PROJECT NO. PR-2019-002277  
Application No. SI-2019-00246

SUBMITTAL DESCRIPTION: DRB Site Plan Resubmittal.

**RE: Adagio Apartments  
PR-2019-002277**

This letter is intended to address comments received related to the Site Plan application heard on October 20, 2021.

PROJECT NAME:	ADAGIO APARTMENTS	
SHEET TITLE:	DETAILS	
SUBMITTED FOR:	DRB DETAILS	
SHEET NUMBER:	C-500

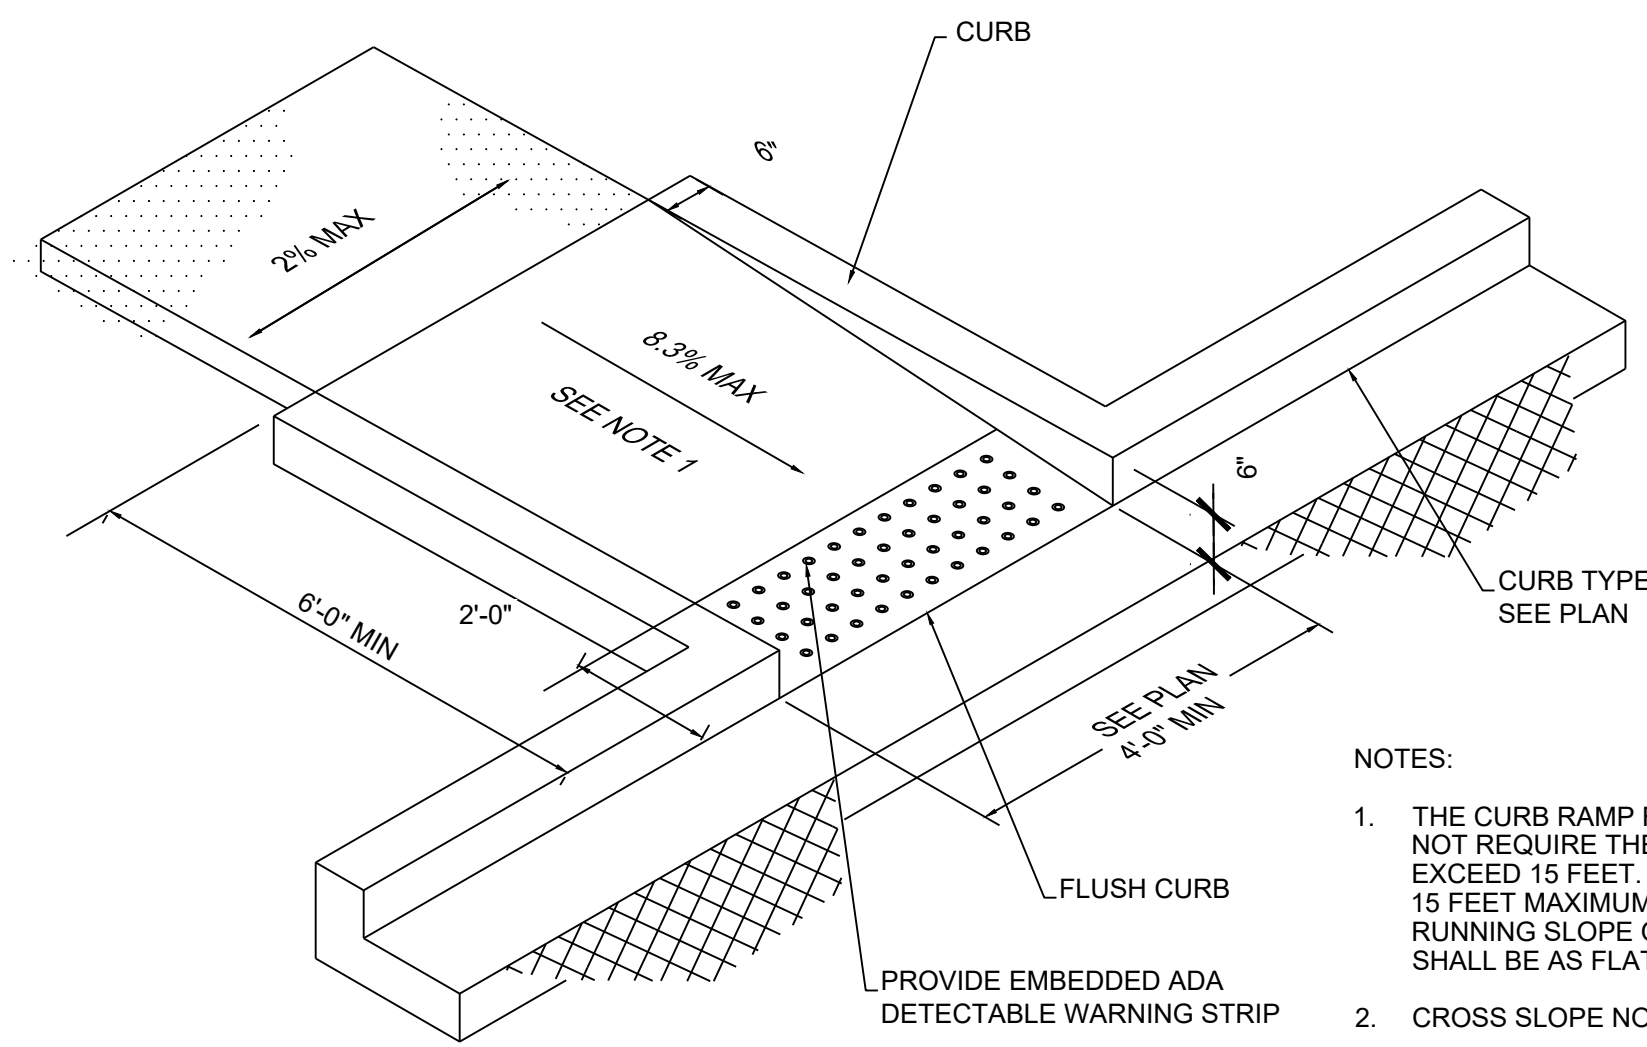
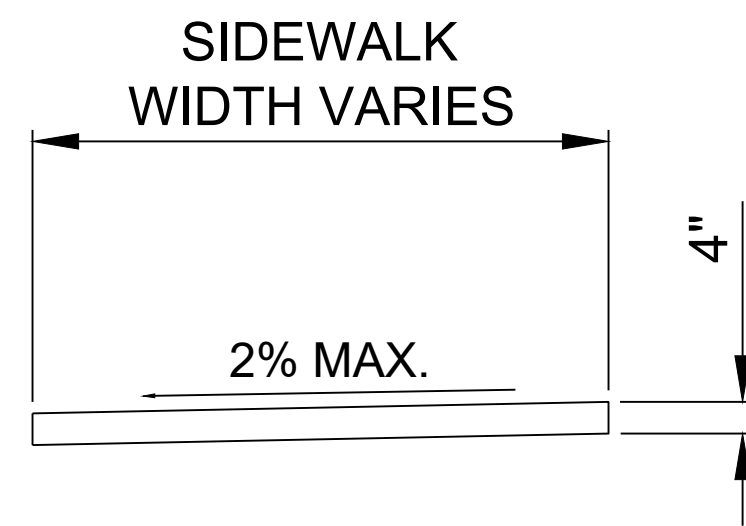
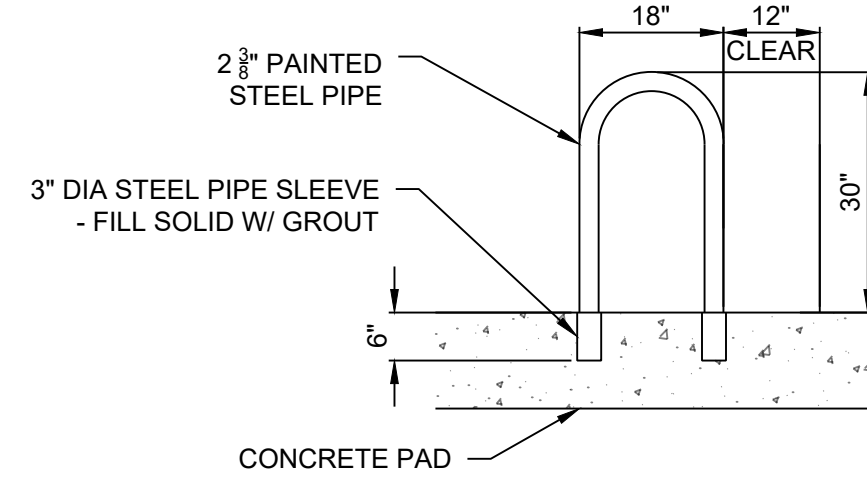
- / Provide more detail at the entrance with regard to ADA accessibility. Provide bike rack detail along with spacing in between bike racks. Provide curb and sidewalk detail showing 2% maximum cross-slope. (Follow IDO/DPM guidelines on needed bike rack details.) (Use correct COA standard detail references for the entrance.)
  - o *Response: A bike rack detail has been included on Detail Sheet C-500 as well as curb and sidewalk details. Driveway entrance on the Site Plan references COA Standard Detail 2420.*

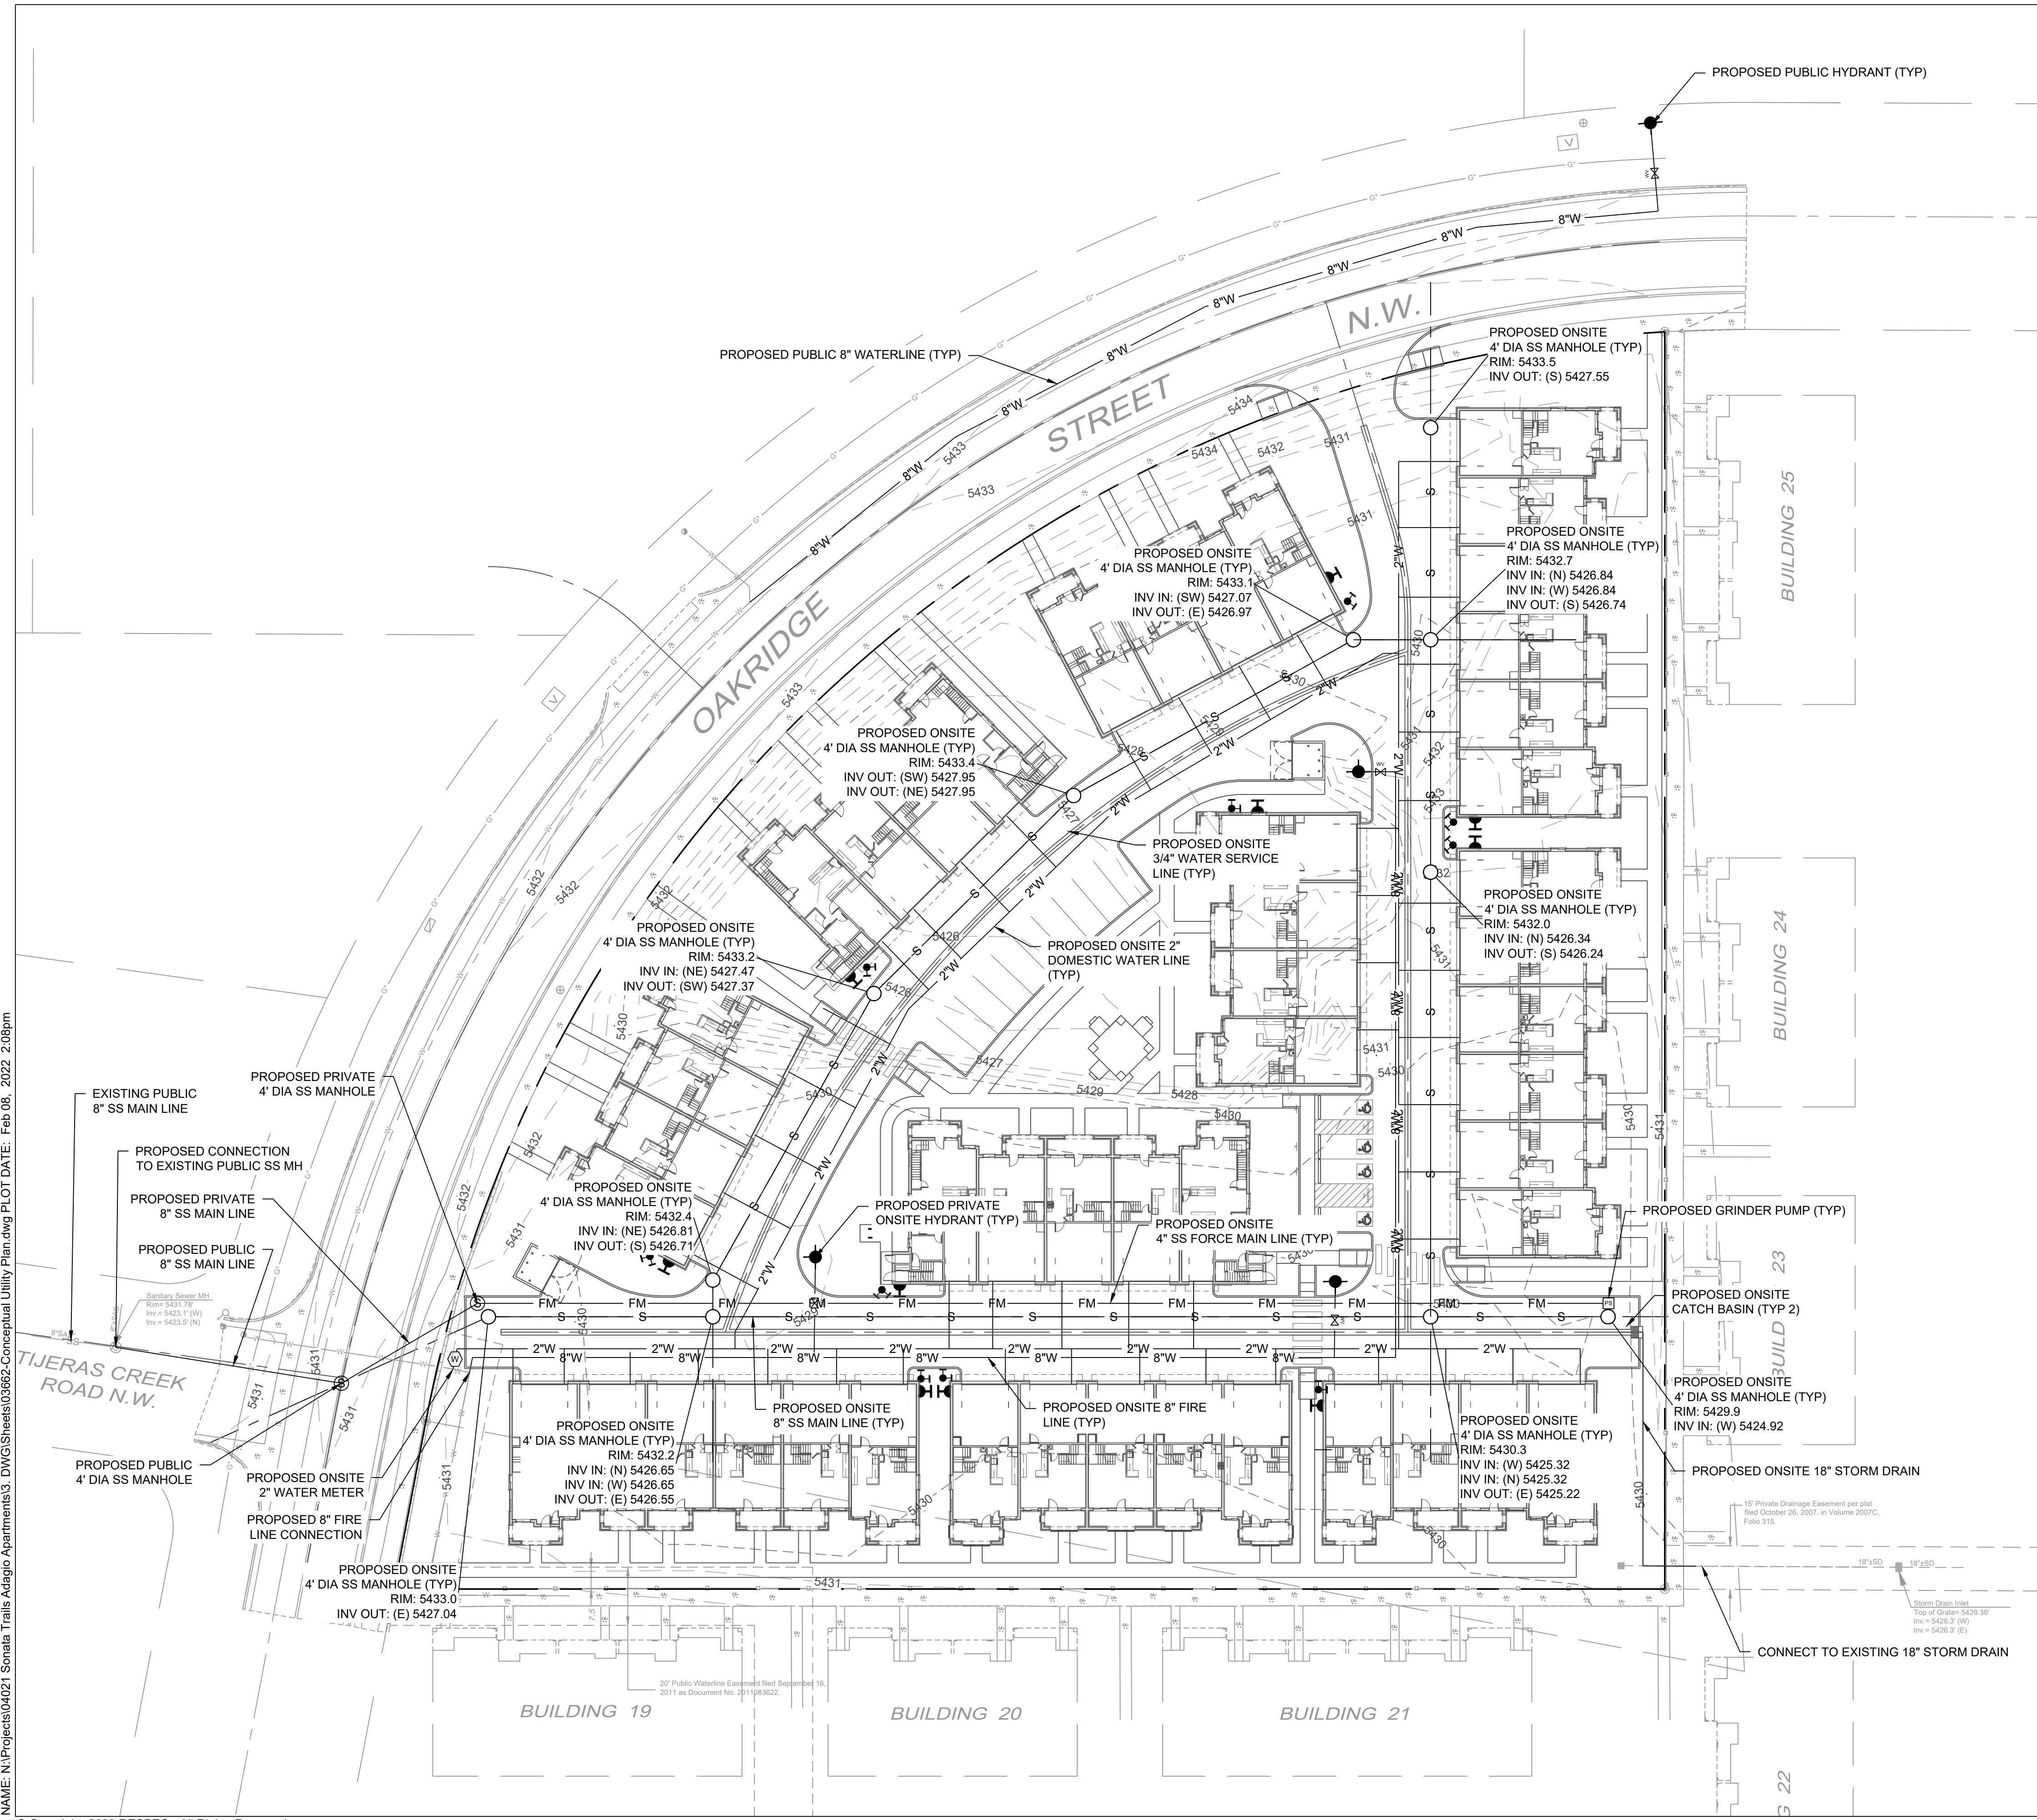
- / Utility Plan
  - The lack of a sewerline in Oakridge requires the update to the serviceability letter and board approval.
    - *Response: Acknowledged.*

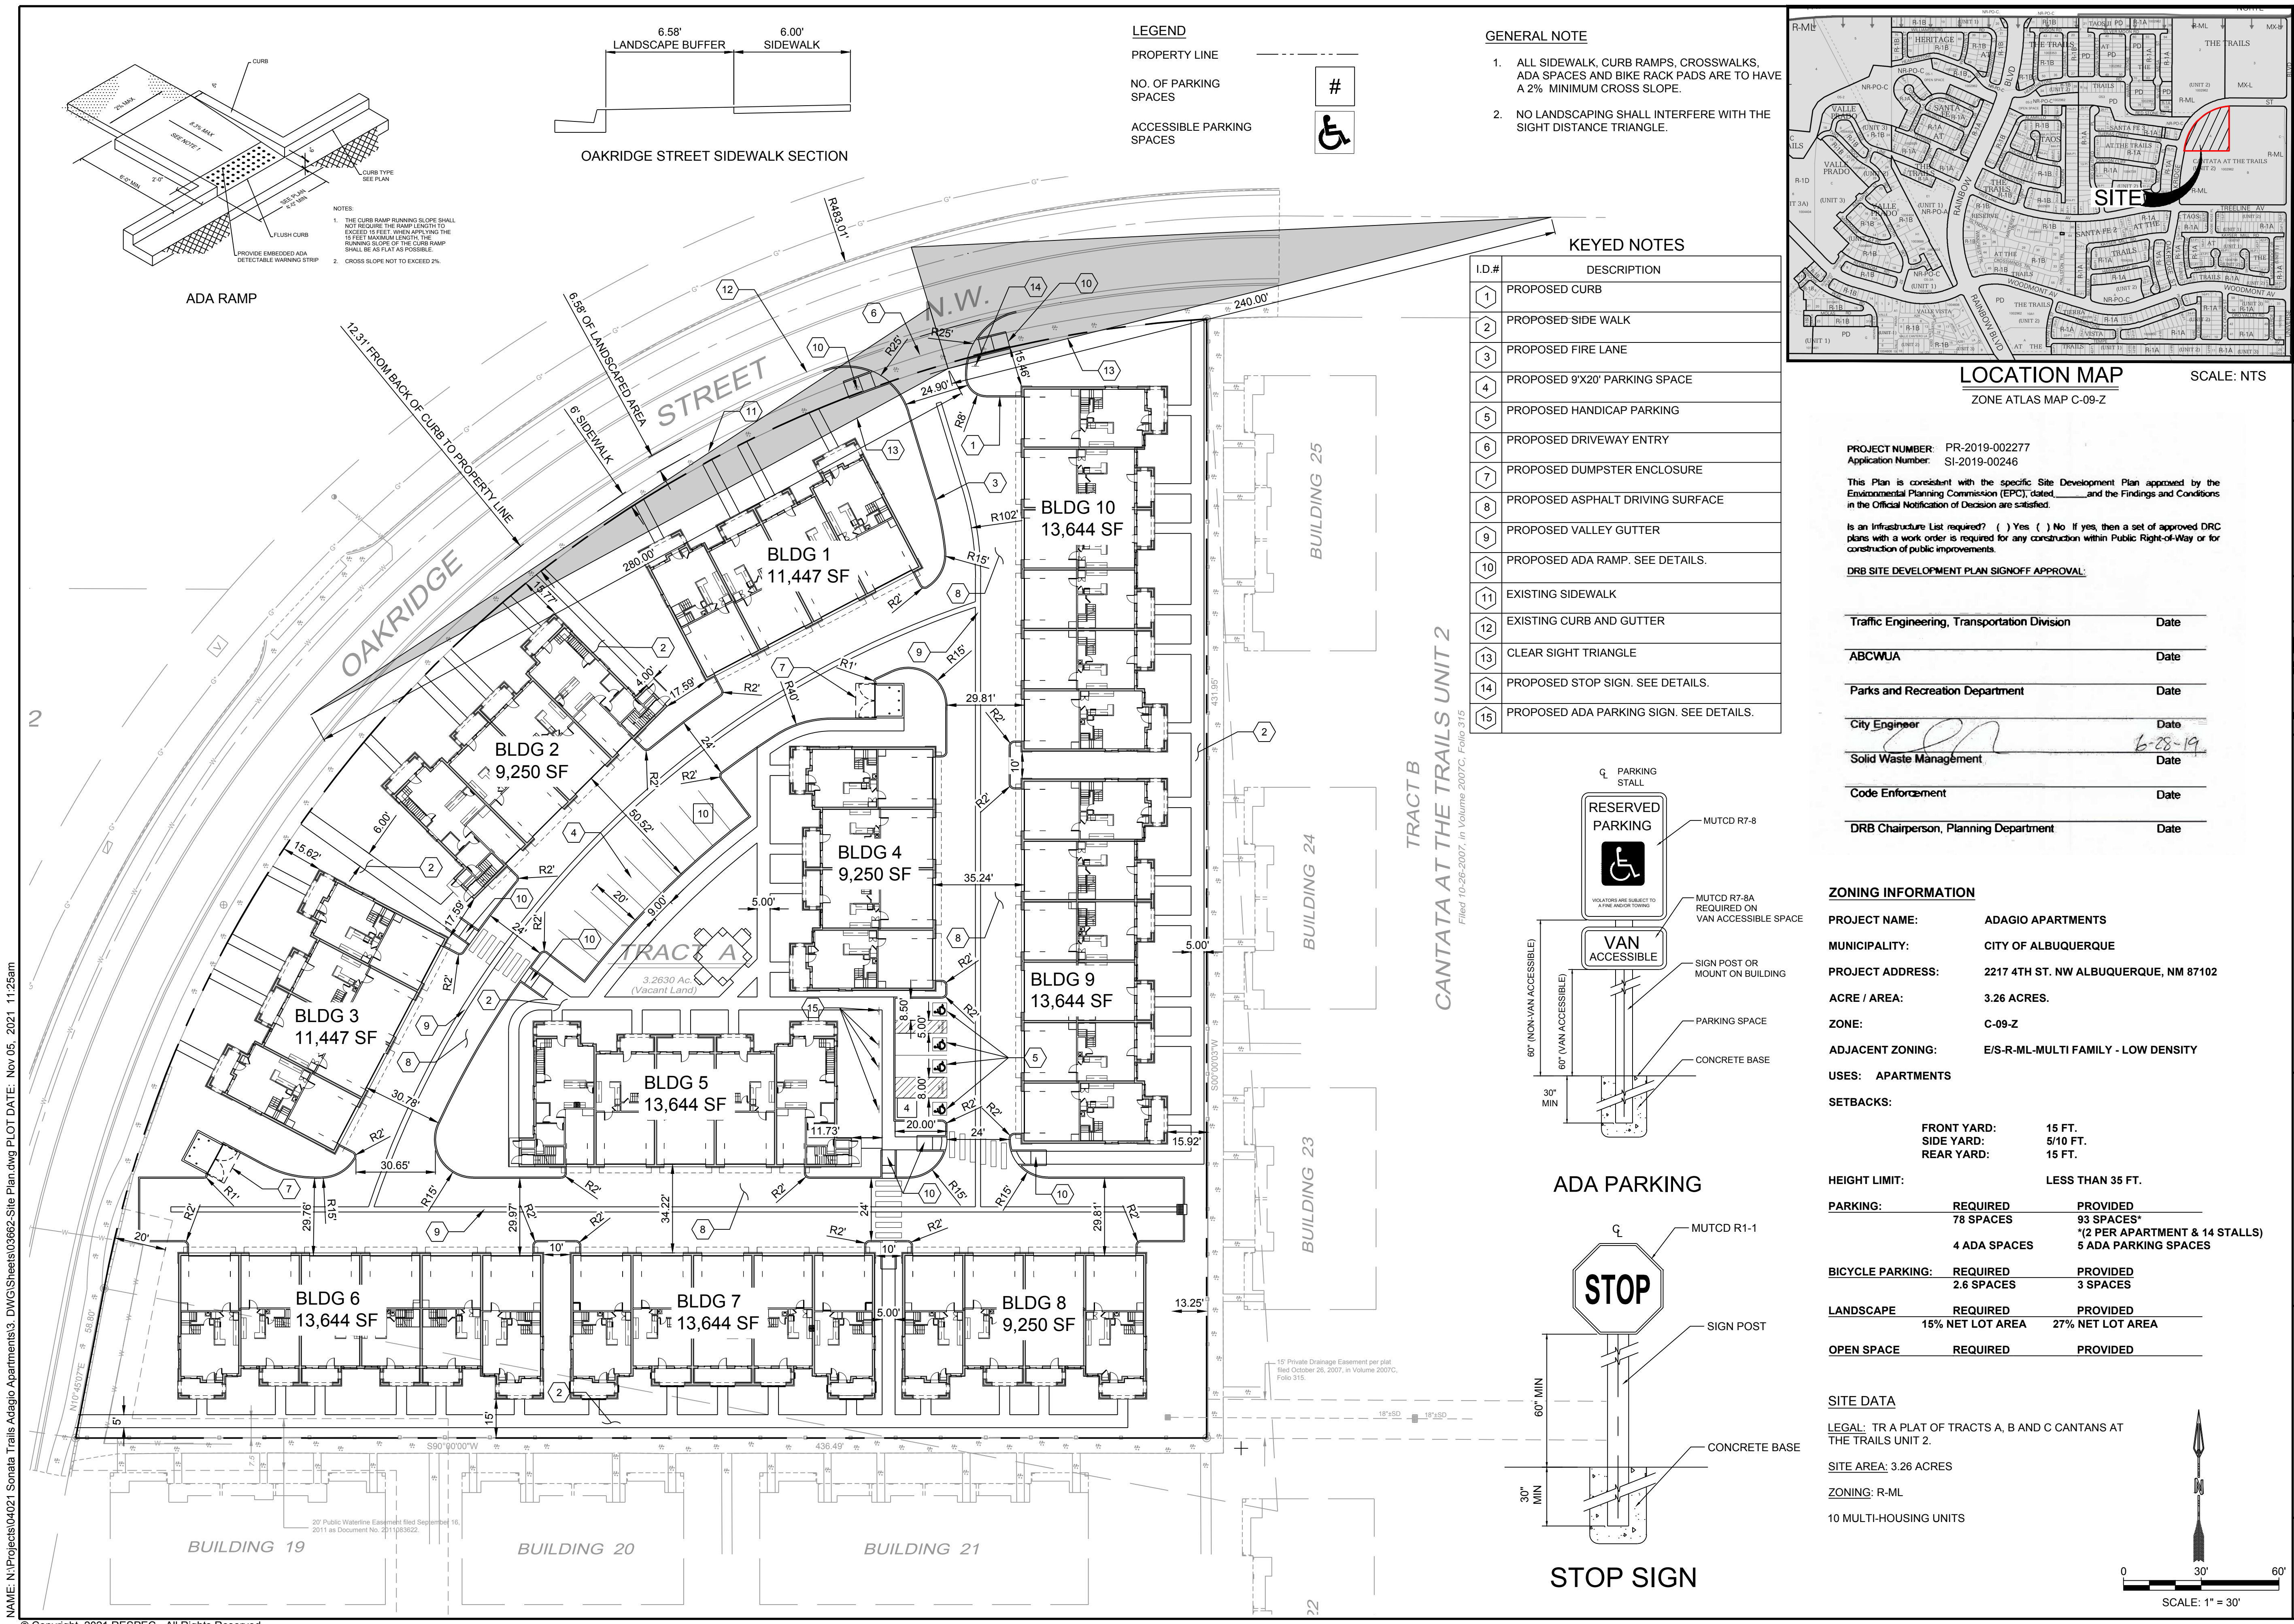
- / Between Buildings 7 and 8, provide curb ramp for ADA accessibility or demonstrate ADA accessibility at this location.
  - o *Response: A keyed note has been added to the Site Plan to show the ADA ramp between Buildings 7 and 8.*

- / Provide all driving aisle dimensions along Buildings 6, 7, and 8.
  - o *Response: Drive aisle dimensions are included along Buildings 6, 7, and 8 on the Site Plan.*

- / Label width of all sidewalks on the plan. (Note this for sidewalk to individual apartments. Typical note can be used.)
  - o *Response: Sidewalk widths are labeled on the Site Plan.*
